MEMORANDUM

TO: Eric Christiansen **DATE:** 8-31-10
FROM: Dianne Popken **AVO:** 27379
EMAIL: @halff.com
SUBJECT: Vitruvian Bridges – Sleeves for Electrical Conduits

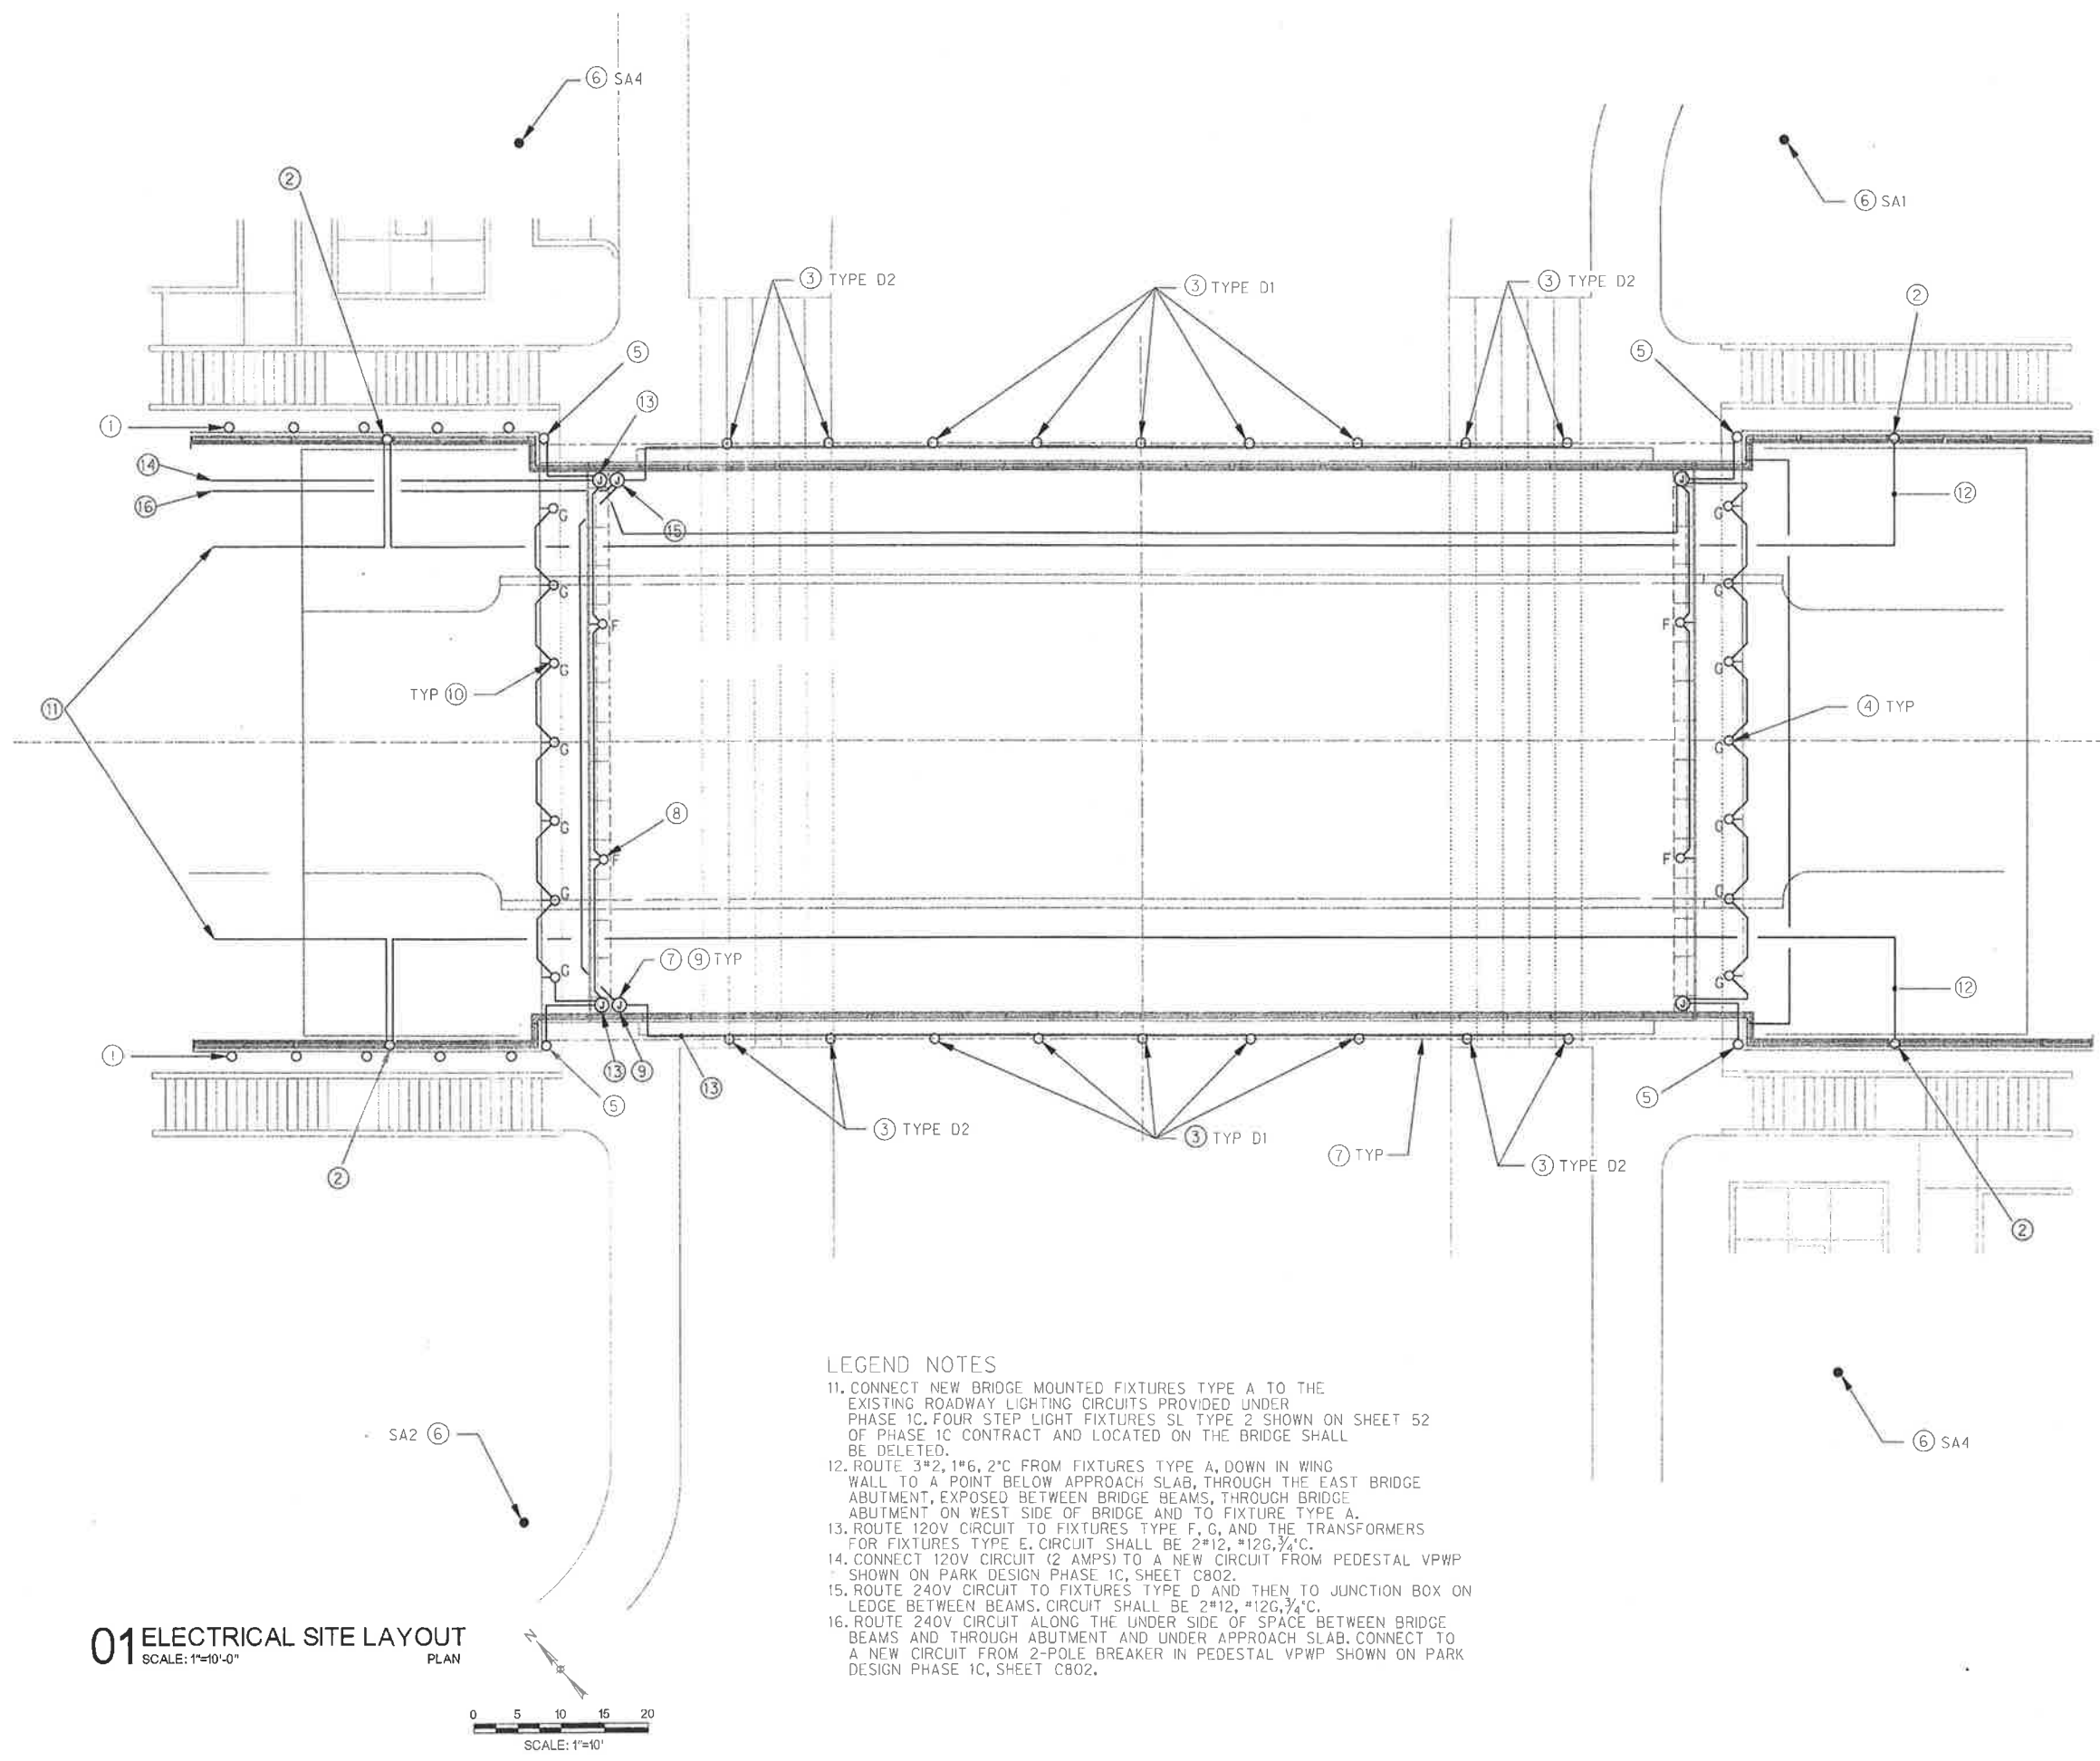
Reference sheet E1-01 , Addendum 5 dated 8-18-10 for electrical service changes:
Note 7 describes cast junction boxes and note 9 describes their location on the bridge beam shelf between the bridge beams. Addendum 5 increased the number of junction boxes required for the circuits to the bridge lighting and the size of conduits serving the junction boxes. For those reasons, galvanized NEMA 4 junction boxes with a hinged and gasket cover and with weather proof conduit connectors and Meyers hubs can be substituted for cast boxes.

The junction boxes can be mounted on the abutment just above the shelf. The junction box for accent lighting can be located outboard of beams #1 and #7. The street lighting and receptacle junction boxes can be located between in spaces on either side of beam #4. Surface mounted conduits under the bridge can be secured to the under side of the bridge deck, between the beams.
